**KIRKLEES METROPOLITAN COUNCIL
INVESTMENT & REGENERATION SERVICE**

**DELEGATED DECISION FOR DISCHARGE OF CONDITION A.4 -
NOTIFICATION OF A PROPOSED ENLARGEMENT TO DWELLINGHOUSE**

Reference no.	2025/HH/92174/W
Site Address	190, Lindley Moor Road, Lindley Moor, Huddersfield, HD3 3UE
Description	The proposal is for erection of single storey rear extension. The extension projects 6m beyond the rear wall of the original dwellinghouse. The maximum height of the extension is 4m, the height of the eaves of the extension is 3m
Recommending Officer	Joanna Rednall

DECISION - REFUSED

Proposed Elevations

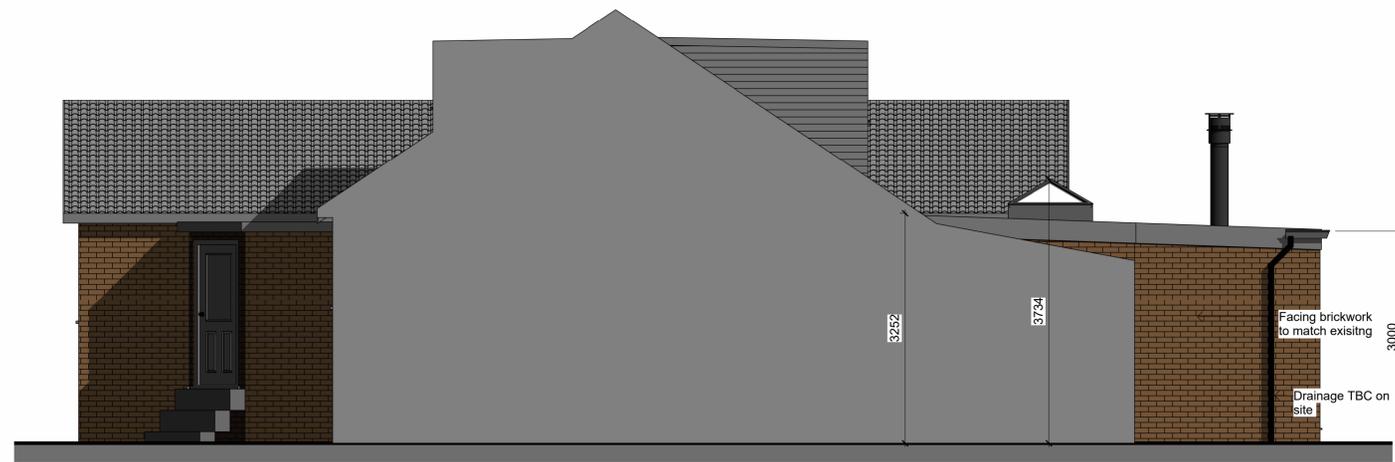
Historic imagery of 190 Lindley Moor Road, held by the Council and dated 1963 show a partial rearward projection, strongly indicating that this feature is original to the dwelling. The submitted plans illustrate that the proposed extension would project from the side of this existing projection—a wall that forms part of the original side elevation of the house. Supporting this, the adjoining property, No. 188, has a mirrored rearward projection, suggesting that Nos. 188 and 190 were built as a matching pair of semi-detached homes. This design pattern is also evident along this section of Lindley Moor Road, with Nos. 186 and 184 displaying a similar layout. Consequently, the proposed enlargement would extend beyond this side elevation and also has a width more than half the width of the original dwellinghouse contrary to paragraph (j) of the Town and Country Planning (General Permitted Development)(England) Order 2015 (as amended).

Having regard to the Government's householder guide to permitted development rights (2019) and sub-paragraph A.1(j), Class A, Part 1 of Schedule 2 of the Town and Country Planning (General Permitted Development)(England) Order 2015 (as amended) development is not permitted under Class A where the proposed extension extends beyond a side elevation of the original dwellinghouse and has a width greater than half the width of the original dwellinghouse. In this case the submitted plans indicate the proposed extension extends 5 metres across rear elevation of the property which is greater than half the width of the original dwellinghouse, and is therefore contrary to paragraph (j) of Class A and as such cannot benefit from a permitted development.
